# STRINGY BARK C · R · E · E · K

**This project is far too large and will adversely affect the neighbouring bushland.**

Proposed Data Centre, 1 Sirius Road, lane Cove West

State Significant Development. SSD 9741, submissions close on 13<sup>th</sup> May. Send to Department of Planning.

Project Status	SSD	
Drawing Title	MASTER PLAN - EGRESS DIAGRAM	
Drawing Number	ATSYD2_SSD_DRG_ARC_0900

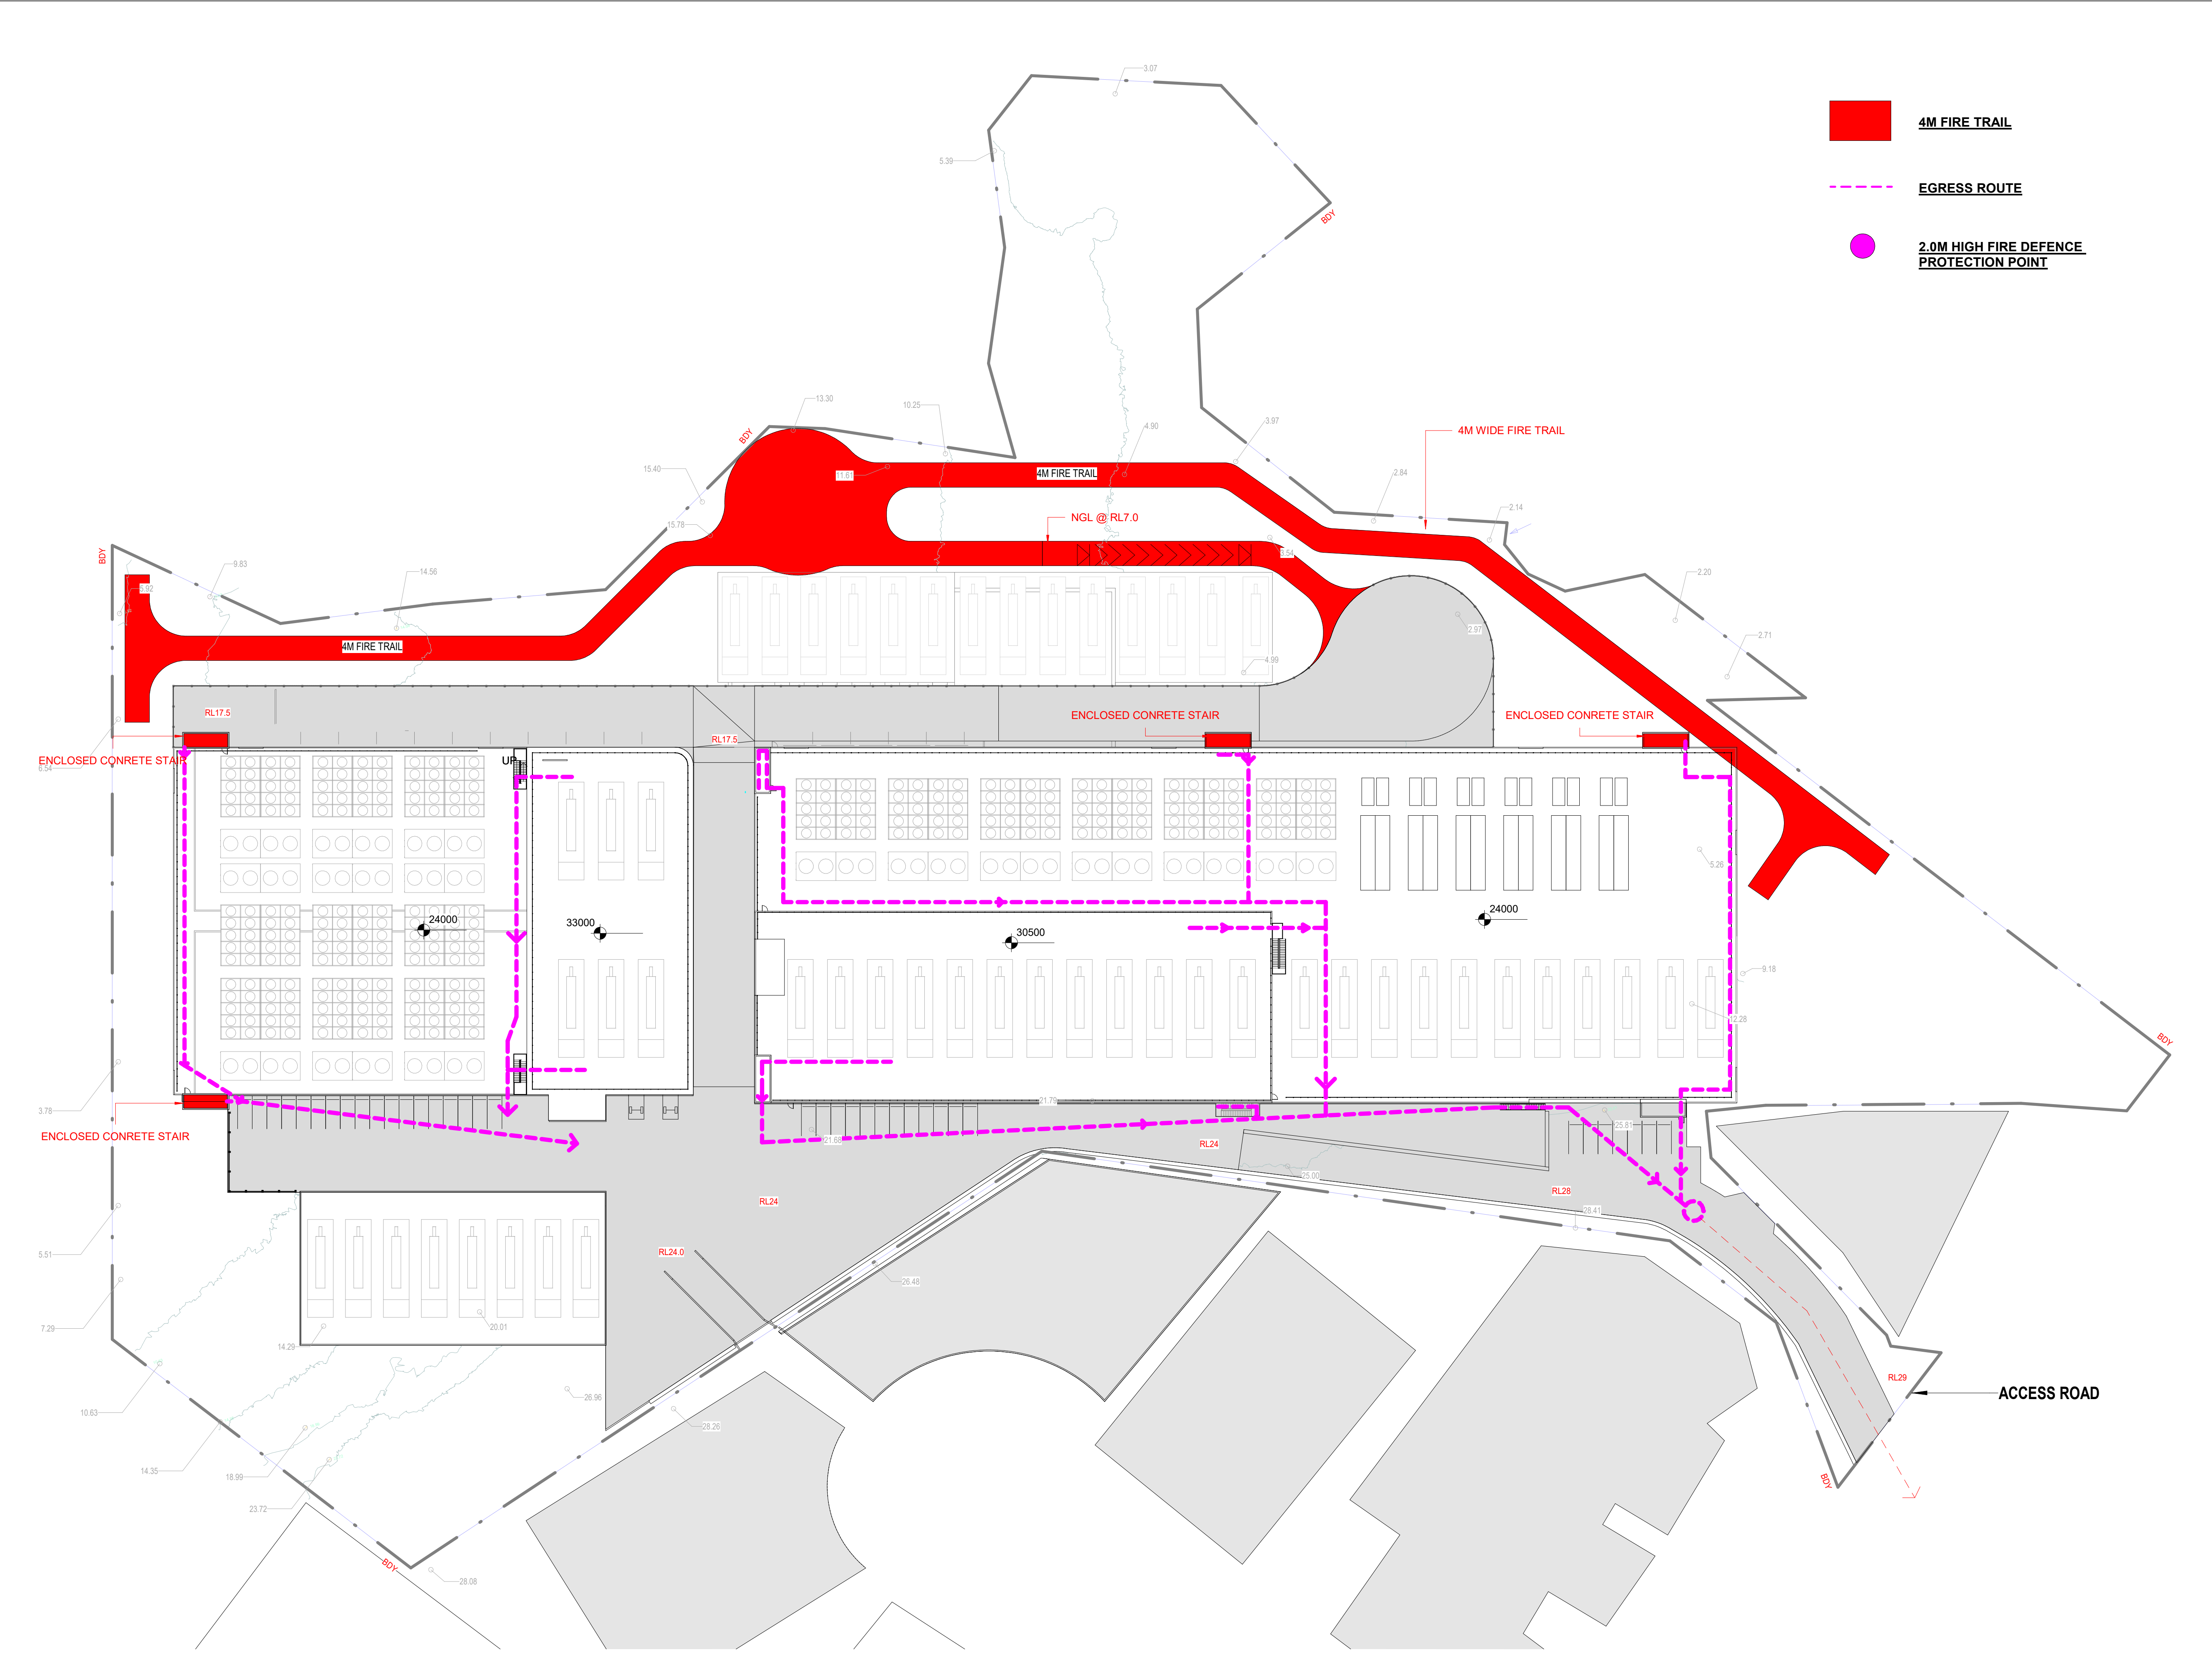
4. This landscape area includes a 4 m wide fire trail made up of perforated elements with grass grown in the open spaces. This is never very successful in providing vegetation of any description.

BULK EARTHWORKS QUANTITIES

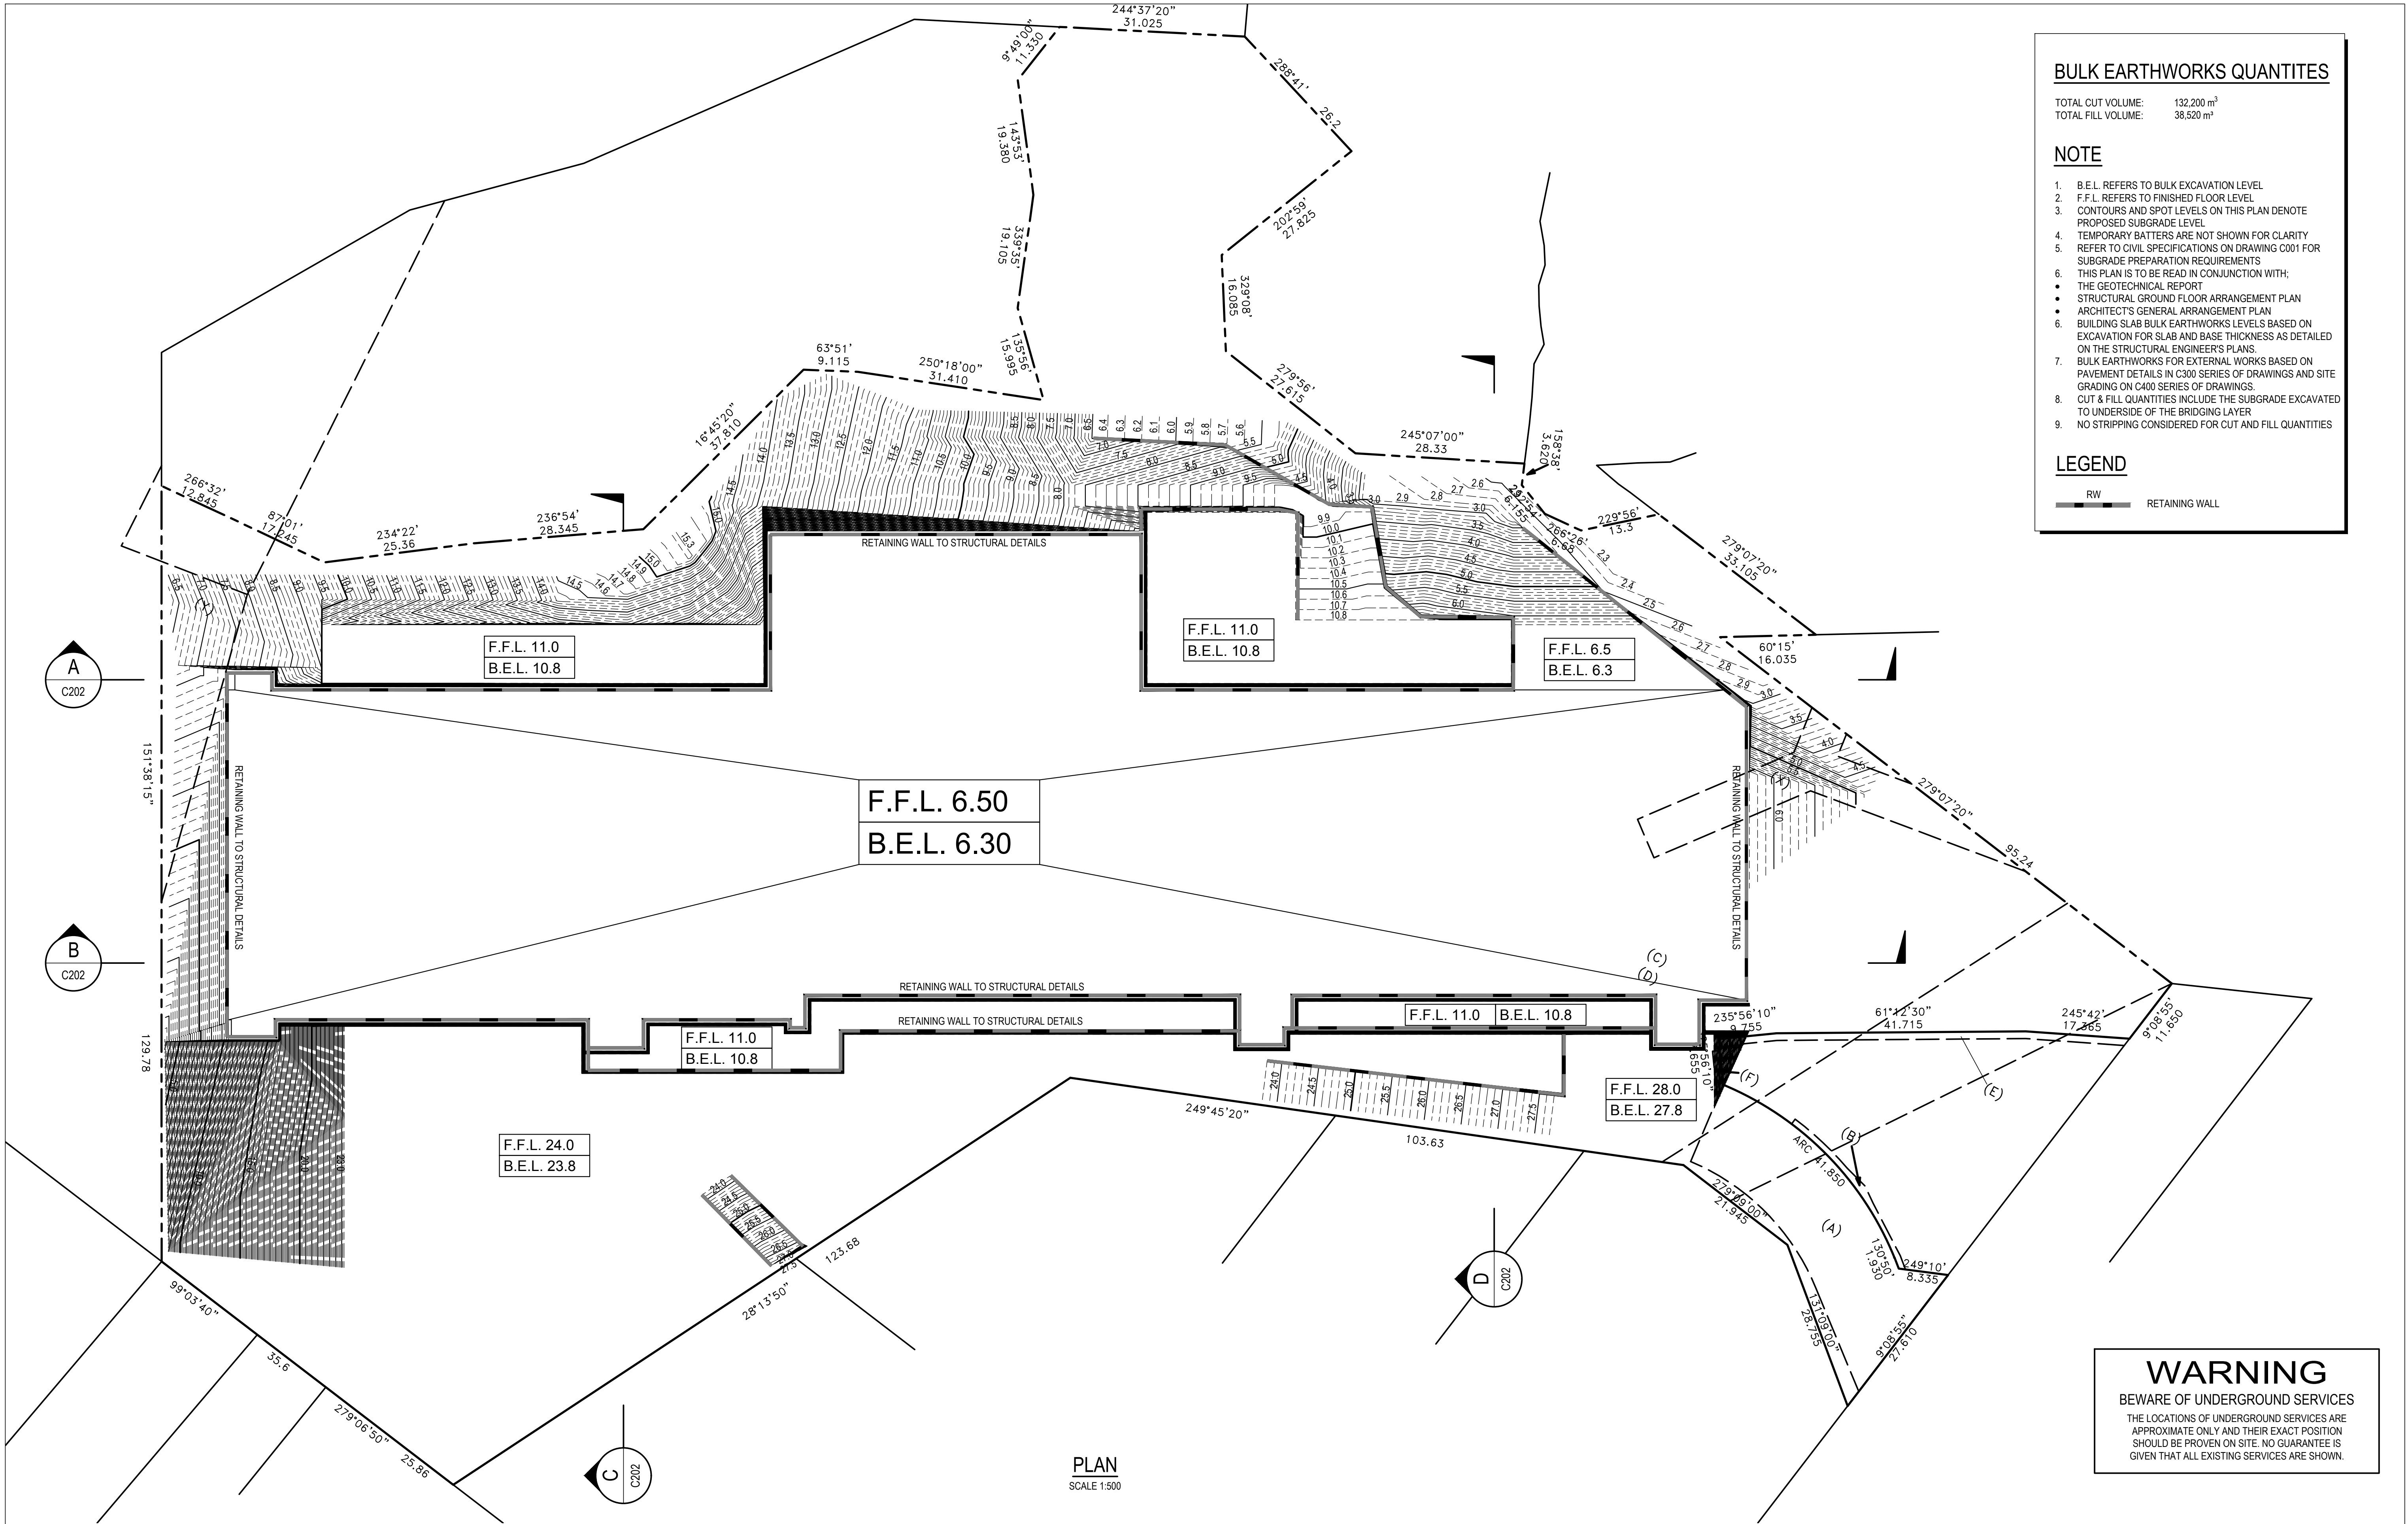
5. There is massive excavation which will affect surface and sub-surface water to the adjoining wetland areas to the south and southwest.
6. Again massive fill will be required in places to provide the levels necessary for the design – parking, truck access to service the plant and the substation. This will affect the sub-surface water.

LEGEND

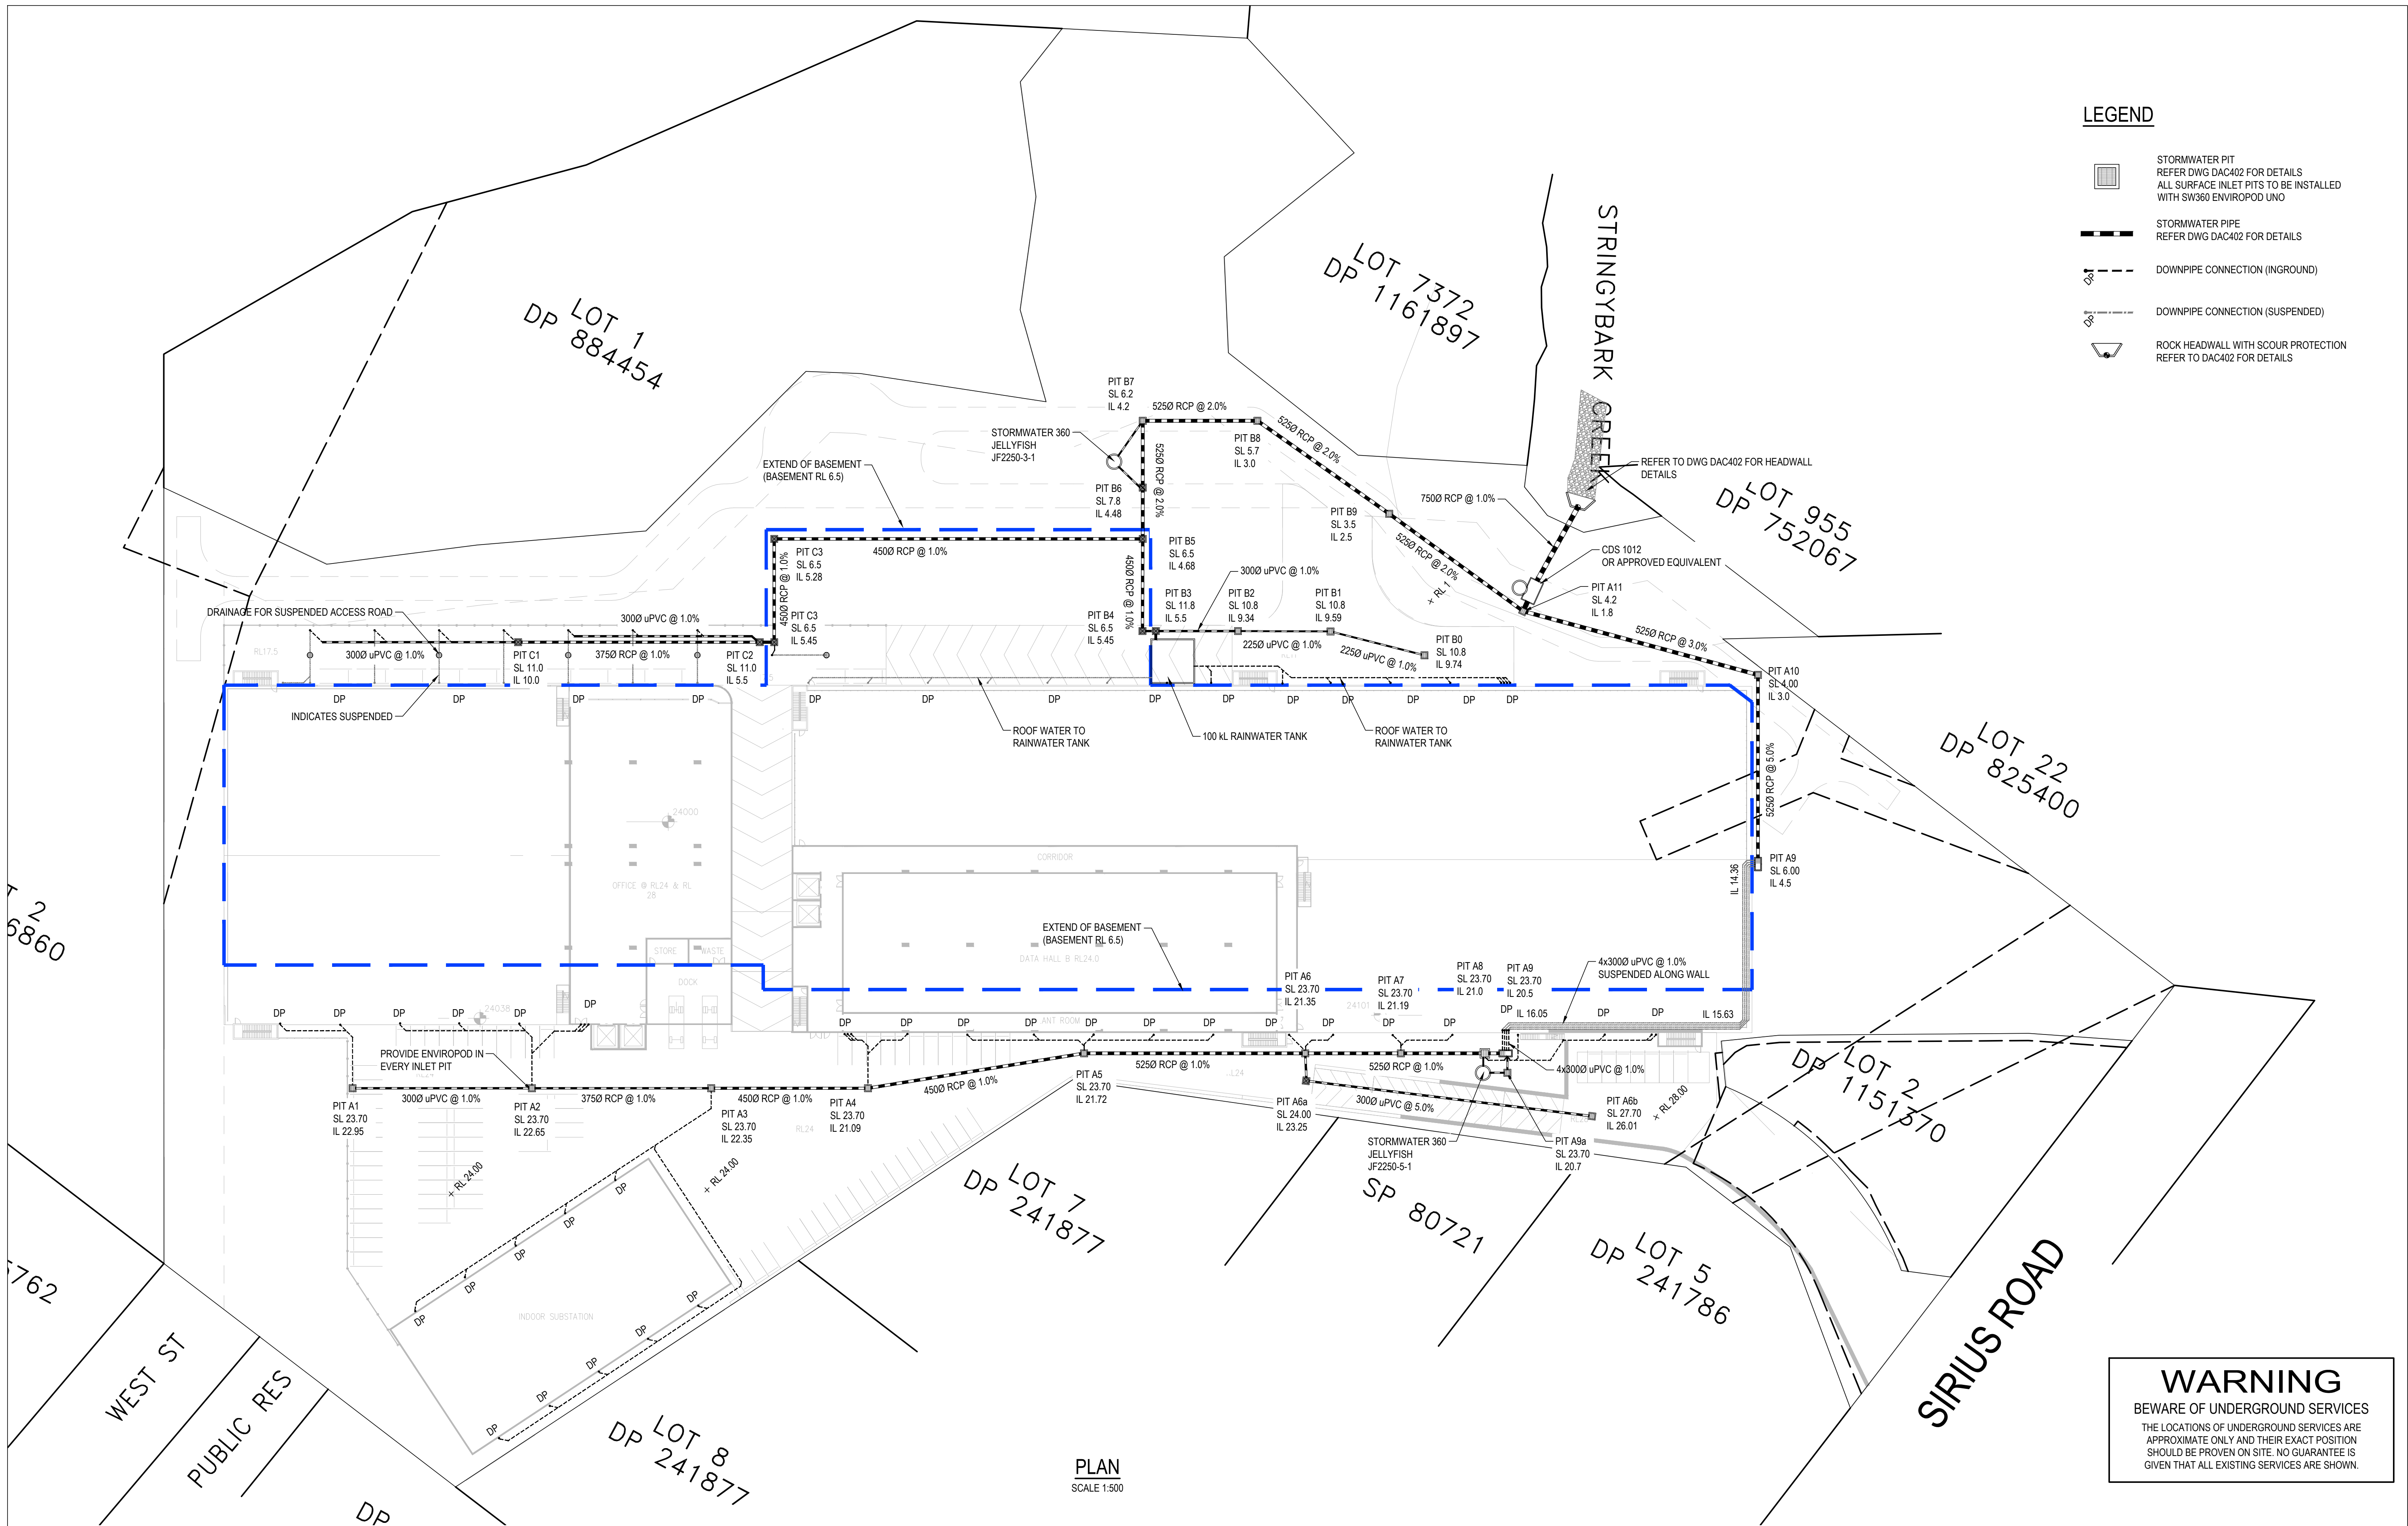
7. All of the stormwater is shown as discharging through a 750 mm pipe into Stringybark Creek (at least it is shown as discharging along the creek and not directly towards the opposite bank)

8. There is a need to direct some of this water to provide sub-surface water to the wetland areas via drainage trenches or similar. This cannot be done to the north because of sealed contaminated land.

9. The remainder of the water should be controlled through either on site detention and/or through a flow dissipater system to reduce the velocity when it reaches the creek.
